Consultation response from KC PROW (footpaths)

2019/91630 4a, Ruth Street, Newsome, Huddersfield, HD4 6JF

Outline application for erection of 30 dwellings and 12 apartments with ancillary works

Date Responded : 4/9/19

Title
Site Plan

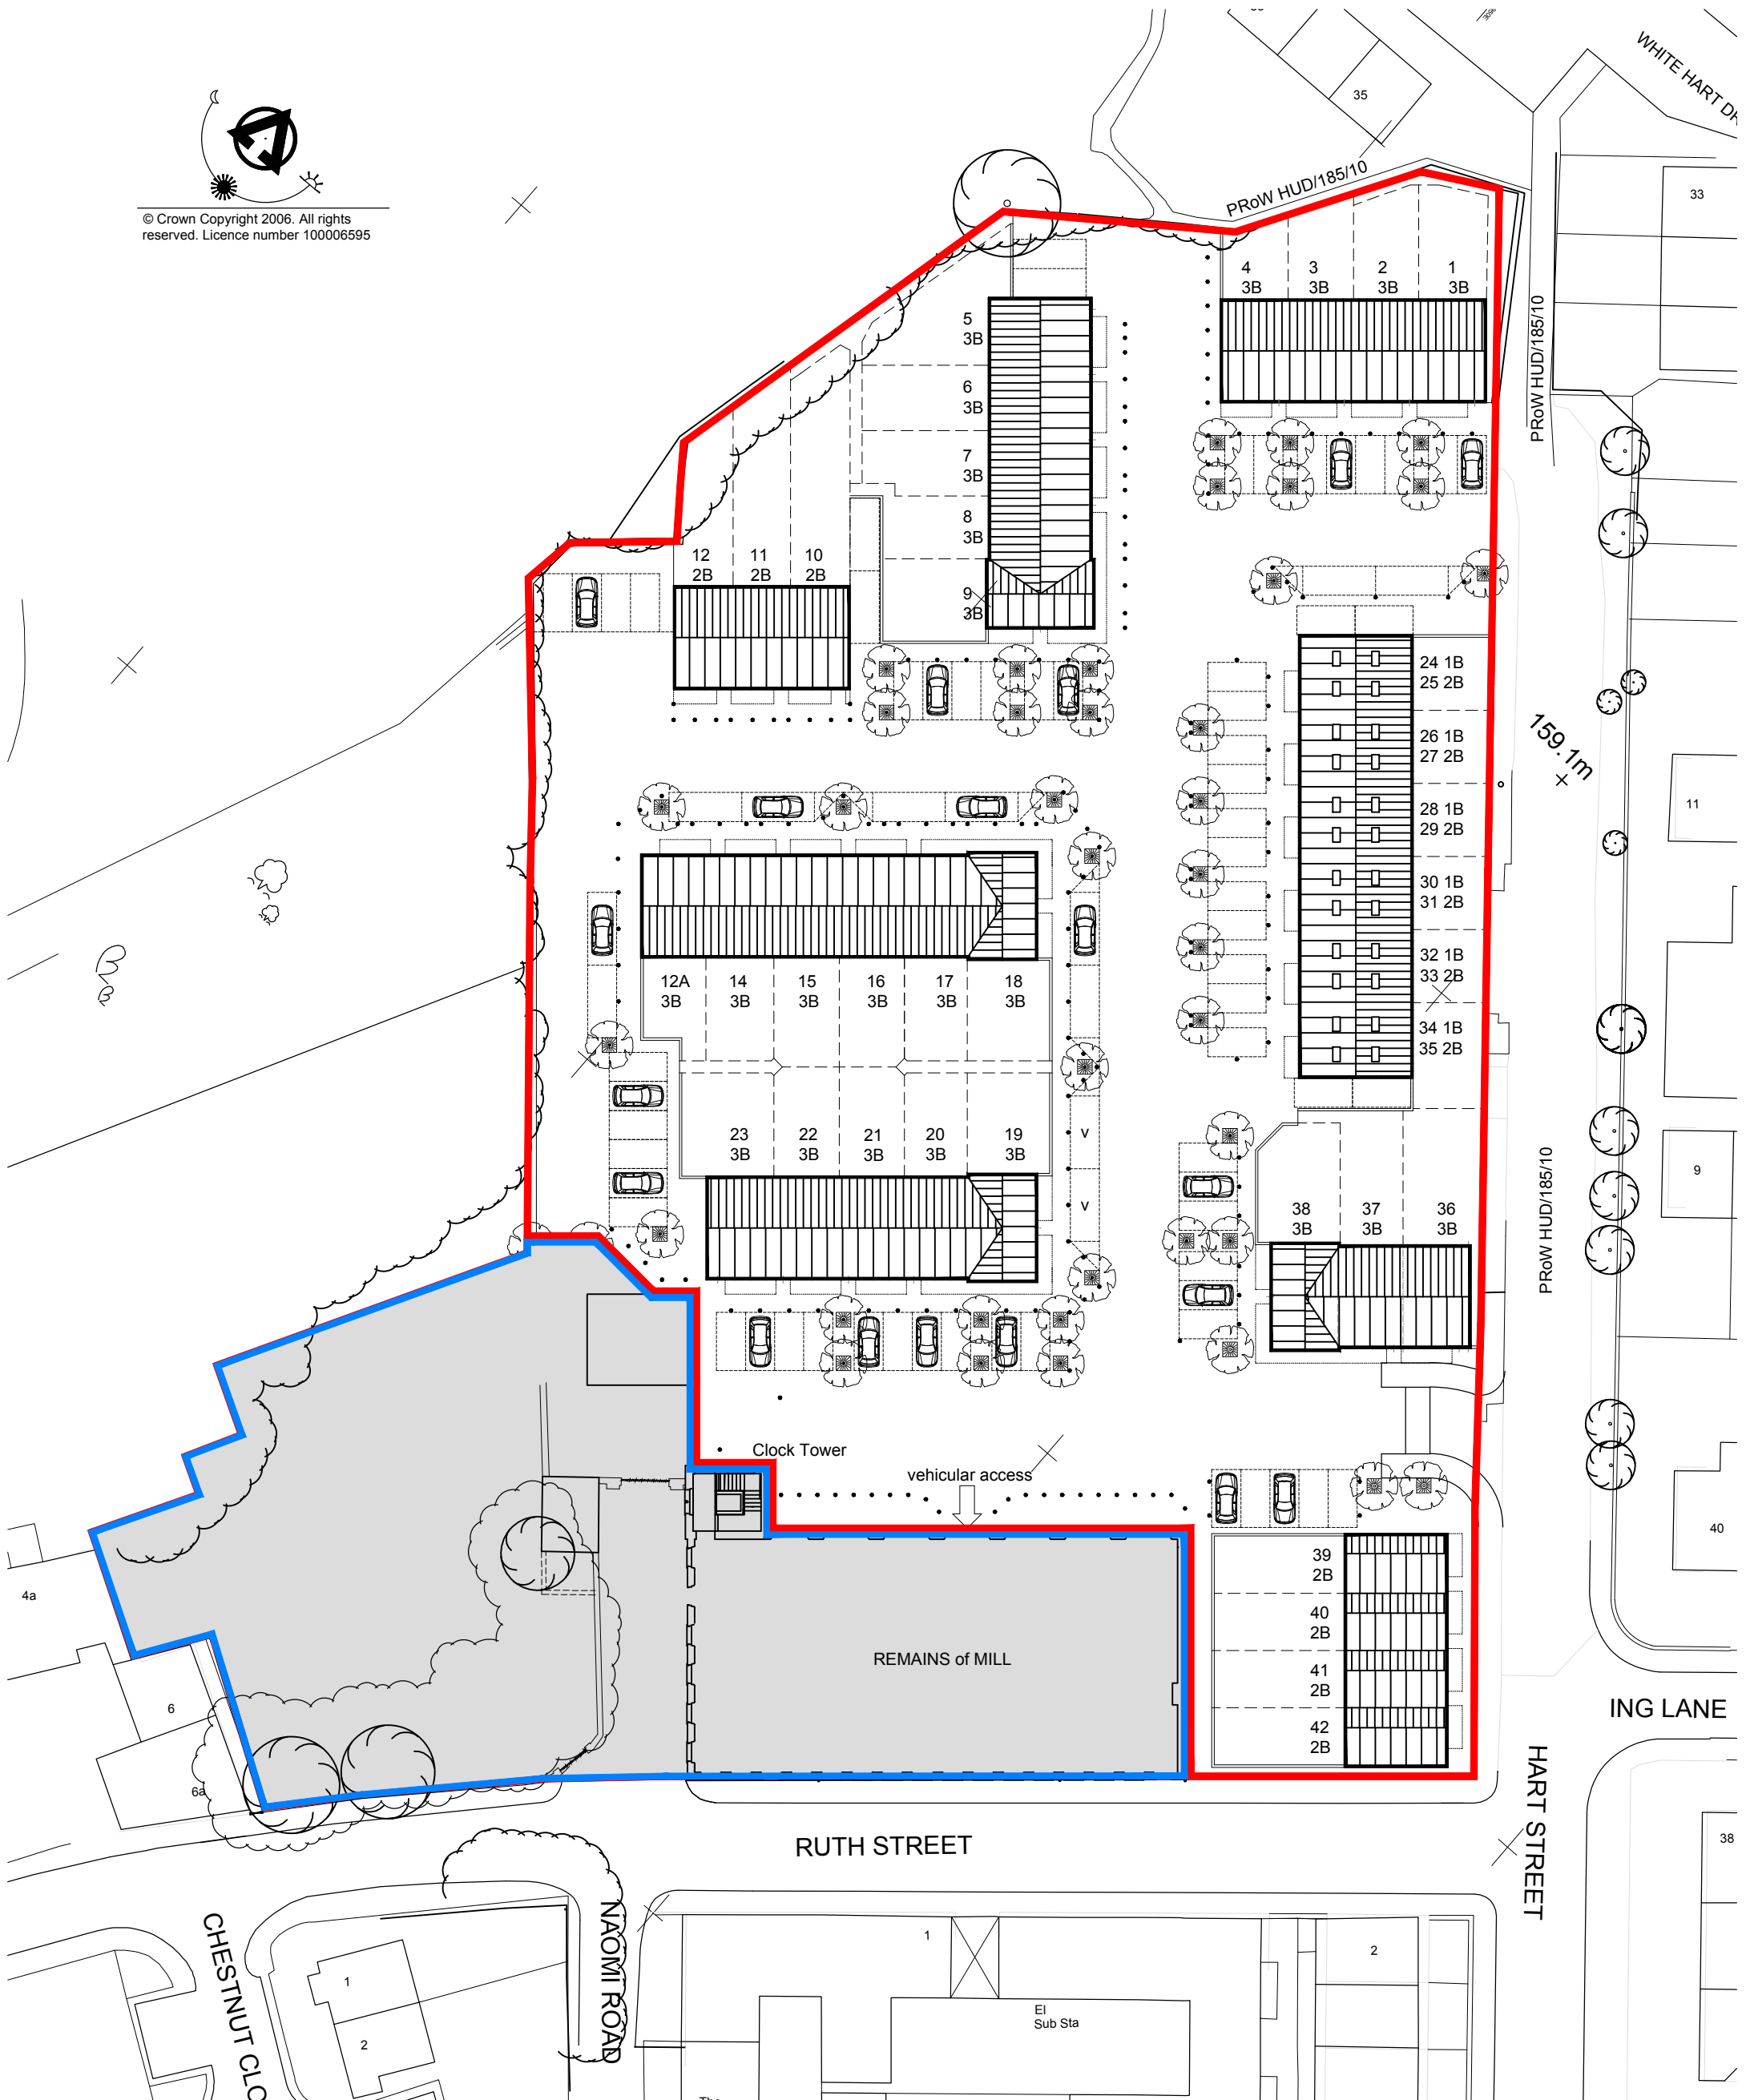
Although this application is outline only, PROW would comment that the application gives no indication of the affect the development will have on the recorded footpath Huddersfield 185. The footpath is the access to the site, and prow would need further information, including the number of access points, surfacing and if this section of Hart Street will be adopted.

FOOTNOTE Public footpath Huddersfield 185 is adjacent to the development site and is the access to the site and must not be interfered with or obstructed, prior to, during or after development works.
